Rezoning Petition Review

Date of Review: September 24, 2020

Rezoning Petition #: 20-122

Location of Property: Approximately 50.03 acres located along the north side of Hucks Rd, along the east side of Arthur Davis Rd and south of I-485.

Rezoning Site Plan
 6106 Hucks Rd., Charlotte, NC 28269

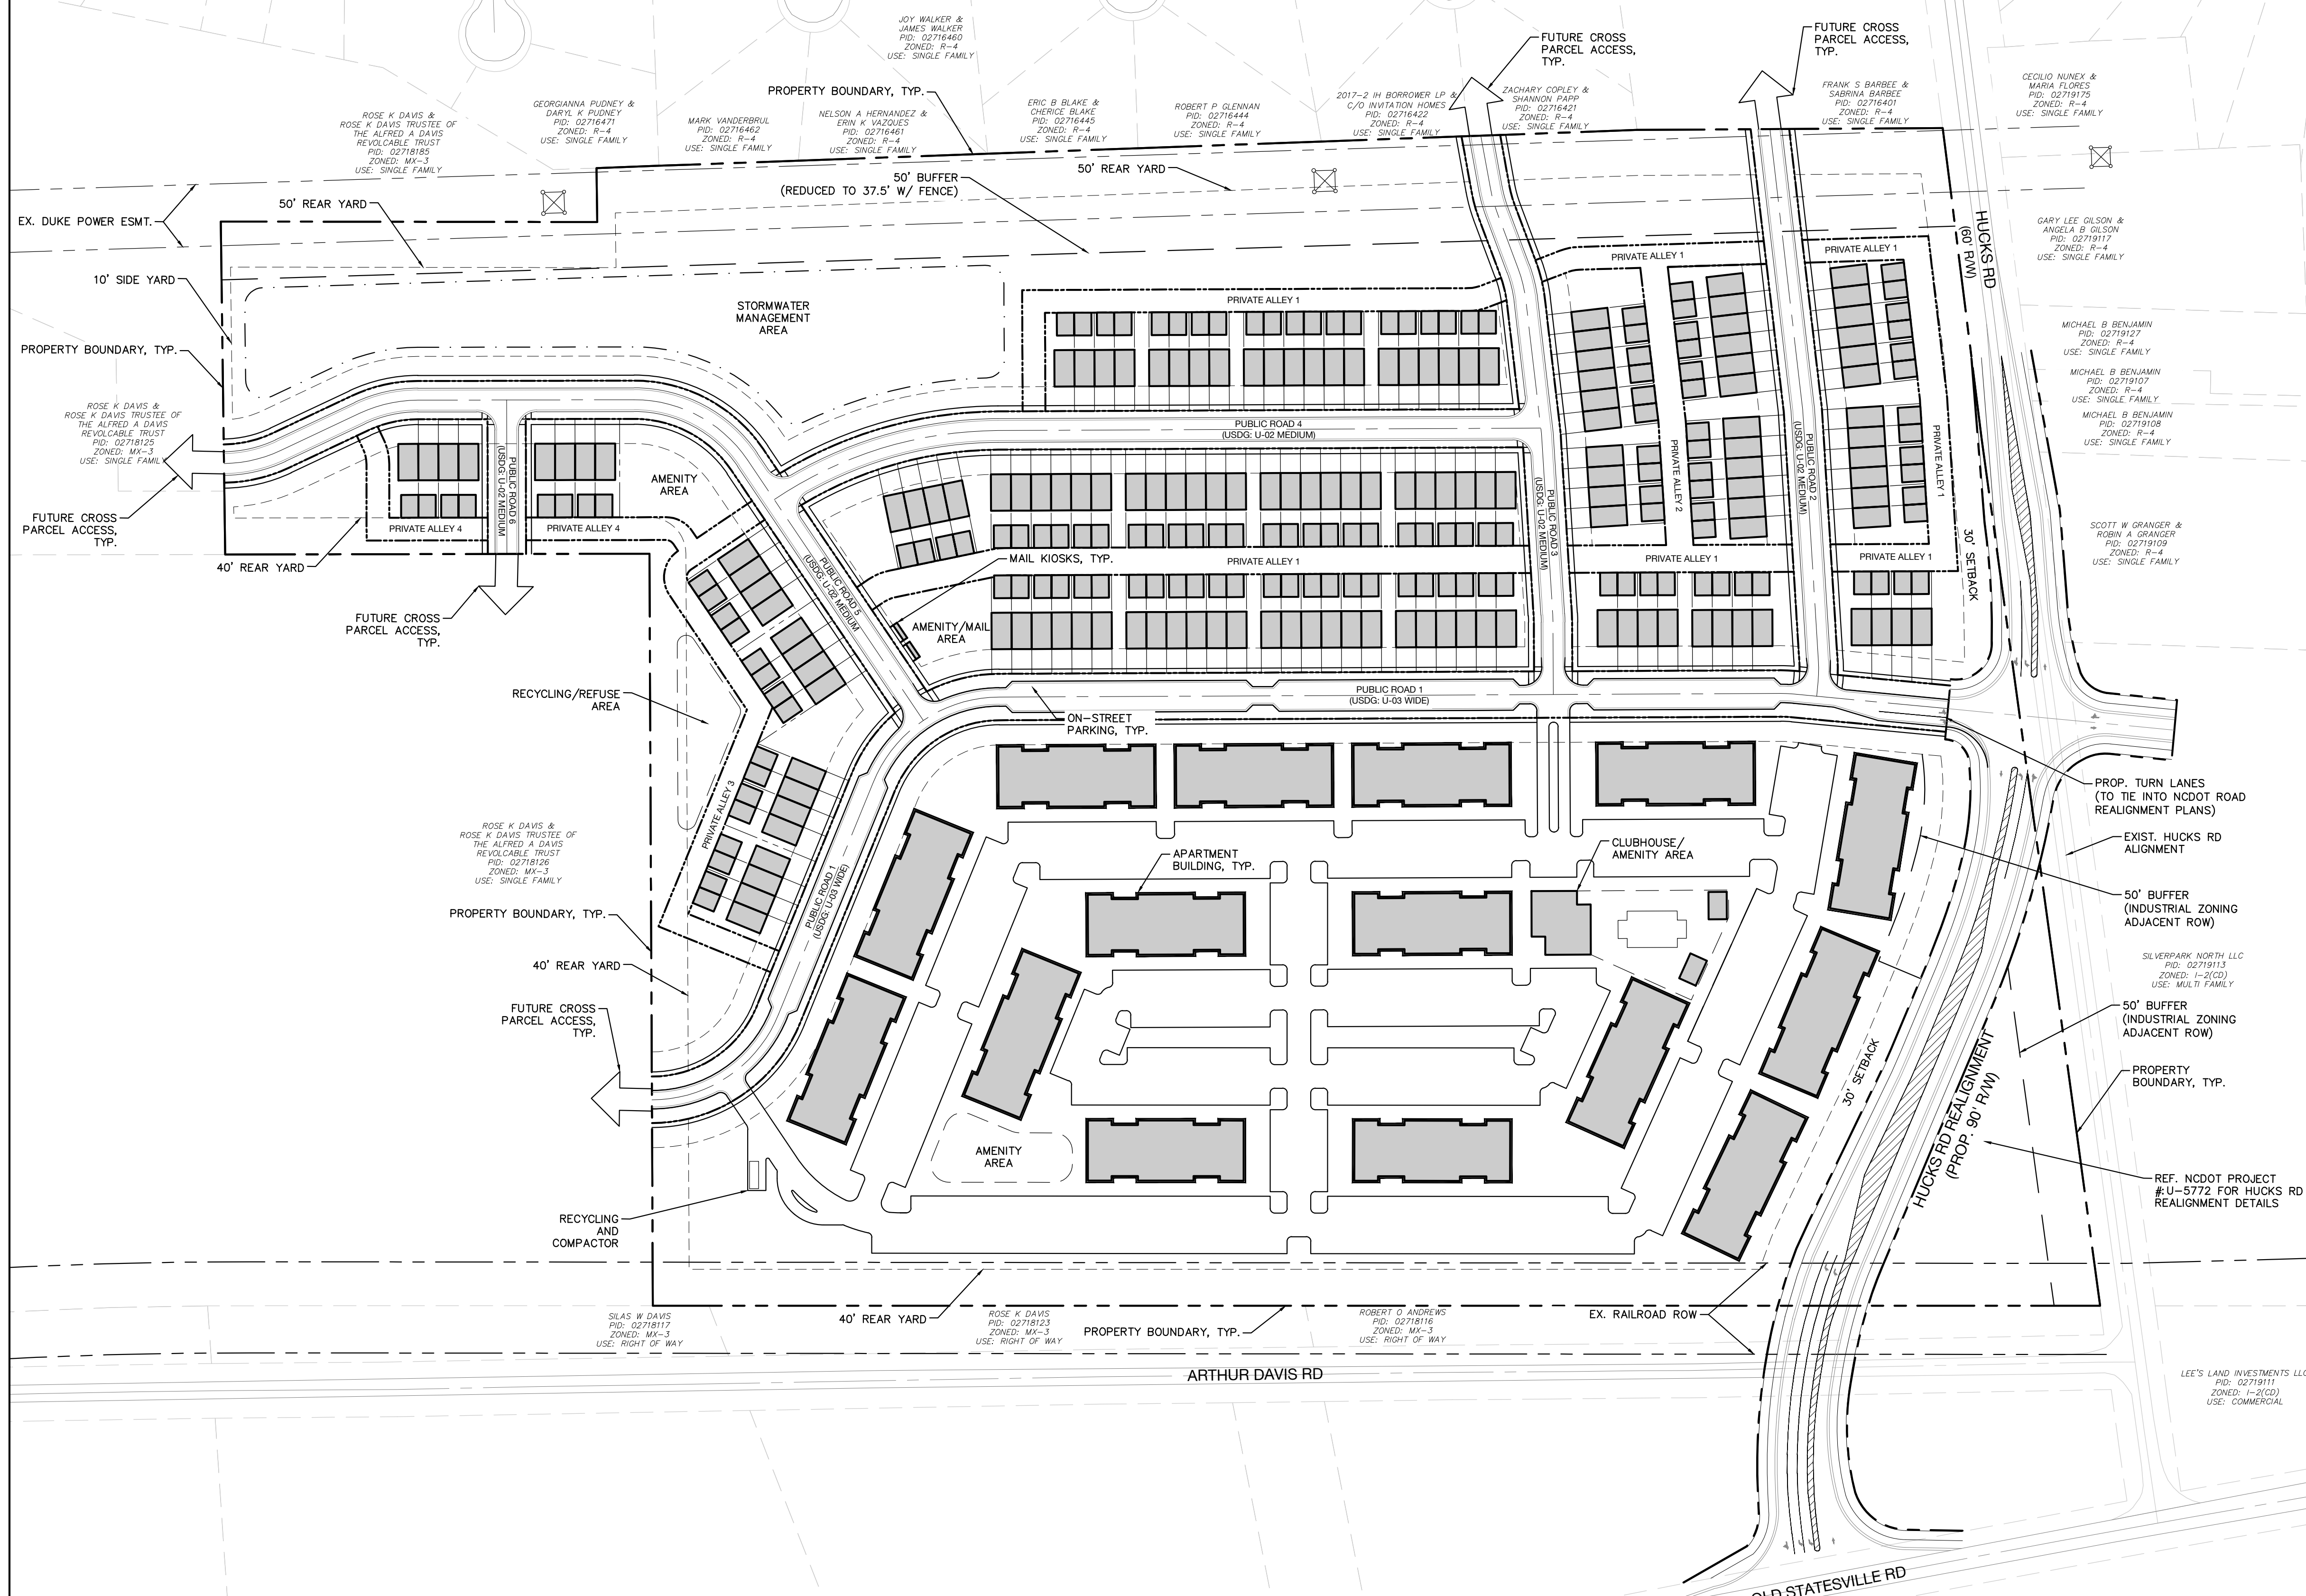
City of Charlotte GIS data indicates a 100-ft Undisturbed PCSO buffer across the site. Please show and label *Potential 100-ft Undisturbed PCSO Buffer* on the site plan. Please note additional SWIM/PCSO Buffers may extend around the existing pond on site. Any increase of impervious area within such buffers may not be allowed and is not approved with the rezoning process. Stream Delineation Reports are subject to review and approval by Charlotte Storm Water Services. Please include the following note under Environmental Features: *“Development within any SWIM/PCSO Buffer shall be coordinated with and subject to approval by Charlotte-Mecklenburg Storm Water Services and mitigated if required by City ordinance. Petitioner acknowledges intermittent/perennial stream delineation reports are subject to review and approval upon submission of development plans for permitting and are not approved with rezoning decisions.”*
